RE: Kendall Bay Sediment Remediation Project (SSD 6701) – Department of Industry Submission on Environmental Impact Statement.

Rock Groyne (Seawall Extension)

Figure 4: Southern Area Stormwater Controls – Rock Groyne and Rock Blanket

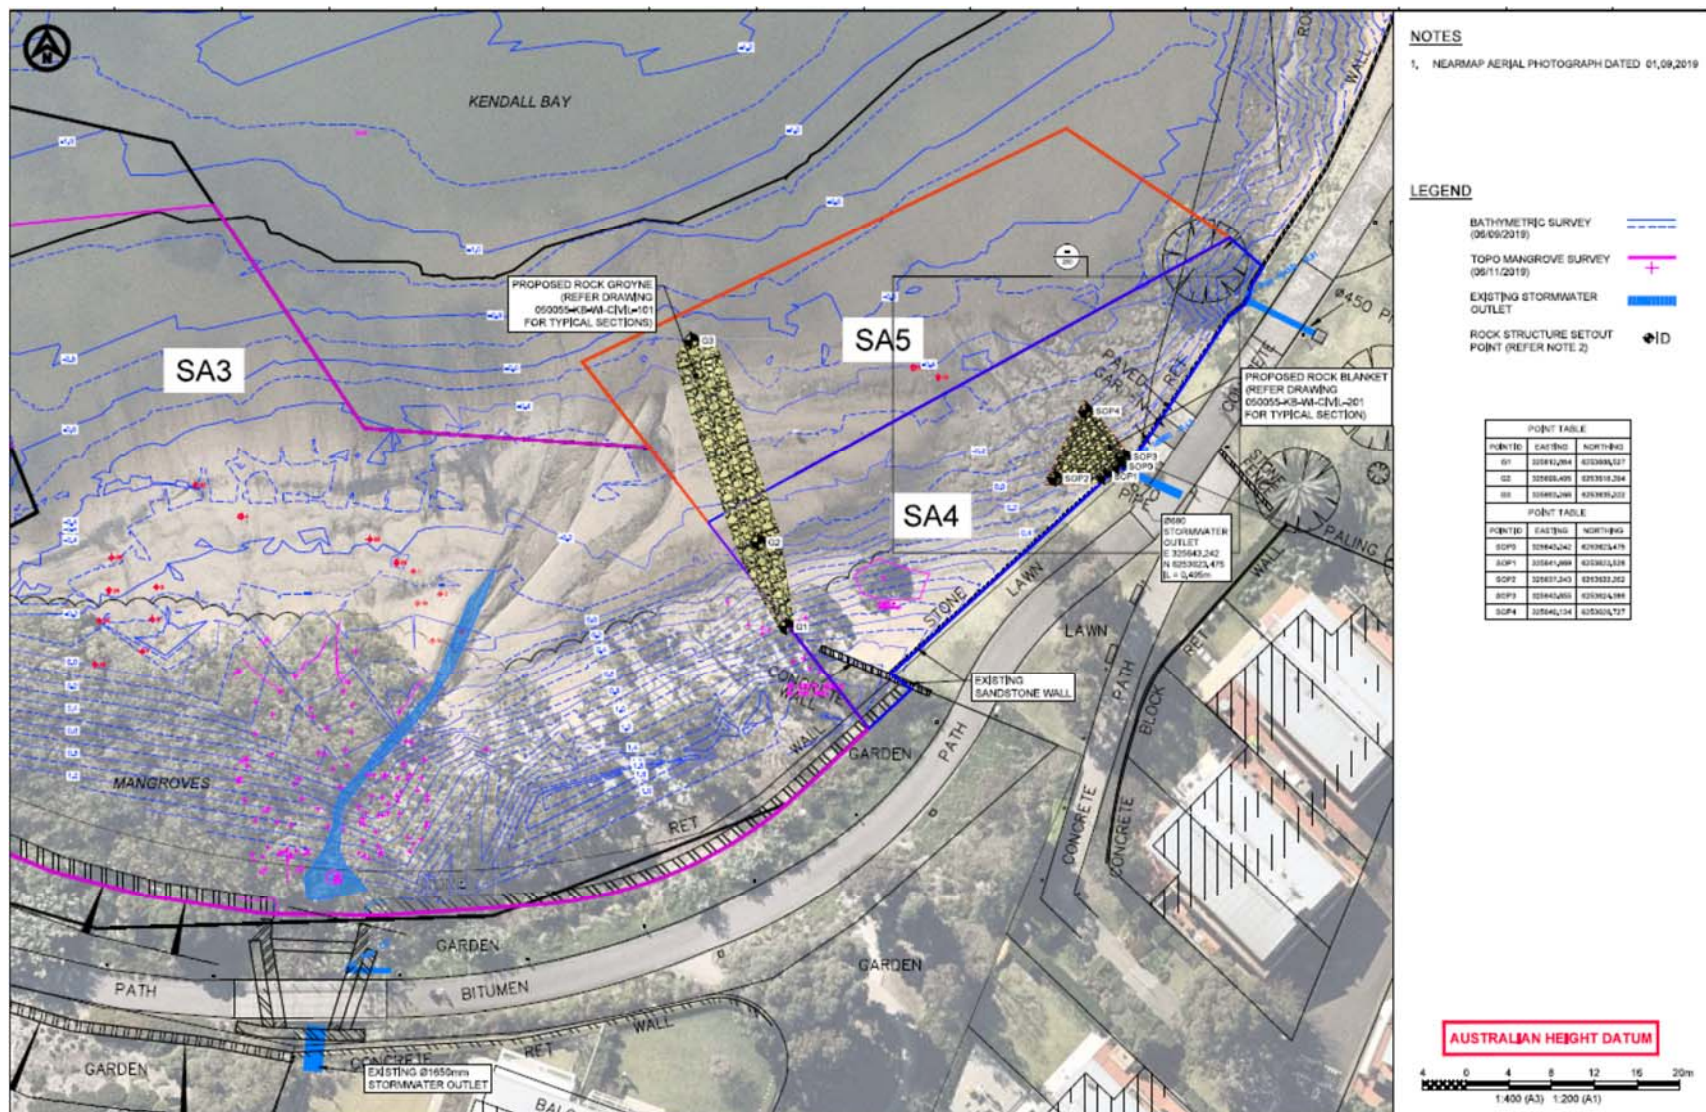
- The department requests further information on the dimensions of the 30m wall to be constructed in area SA4 and what it will likely be constructed with. A rip rap design to promote aquatic habitat diversity over time is recommended.

The approach to the construction of the rock groyne wall is described below. We believe this design meets Fisheries recommendation for a rip rap design which promotes aquatic habitat diversity on this wall over time.

The groyne wall will be constructed sequentially in sections prior to the replenishment of sand in SA4 and SA5. The sub-base will be prepared by an 8T excavator, levelling the natural surface along the alignment prior to placement of geotextile fabric and geogrid liners. The eastern section of the groyne wall will be constructed allowing the internal geofabric barrier, which prevents the mobilisation of sand through the groyne wall, to be placed and secured. The western section will then be placed to complete the wall. Quarried sandstone material which is compliant to the design grading envelope will be delivered to the Tennyson Road facility (staging area) and placed on material barges for transport to Kendall Bay. The 8T excavator will unload the material. It will be transported by power barrows and a skid steer loader to the designated placement location. Placement of the individual sandstone pieces will be via the 8T excavator. Where practicable, sandstone cobbles will be site won through a sieving process at the beaches of SA3, SA4 and SA5 and from remediation areas SA1, SA2, NA1 and NA2/3. Cobbles that fall within the design grading envelope and are clean and free from contaminants will be reused.

The rock groyne will consist of graded sandstone cobbles up to a maximum size of 0.56m in diameter. Geofabric will be required at the base and within the cross section of the wall. The typical concept section of the rock groyne is shown in the figure above.
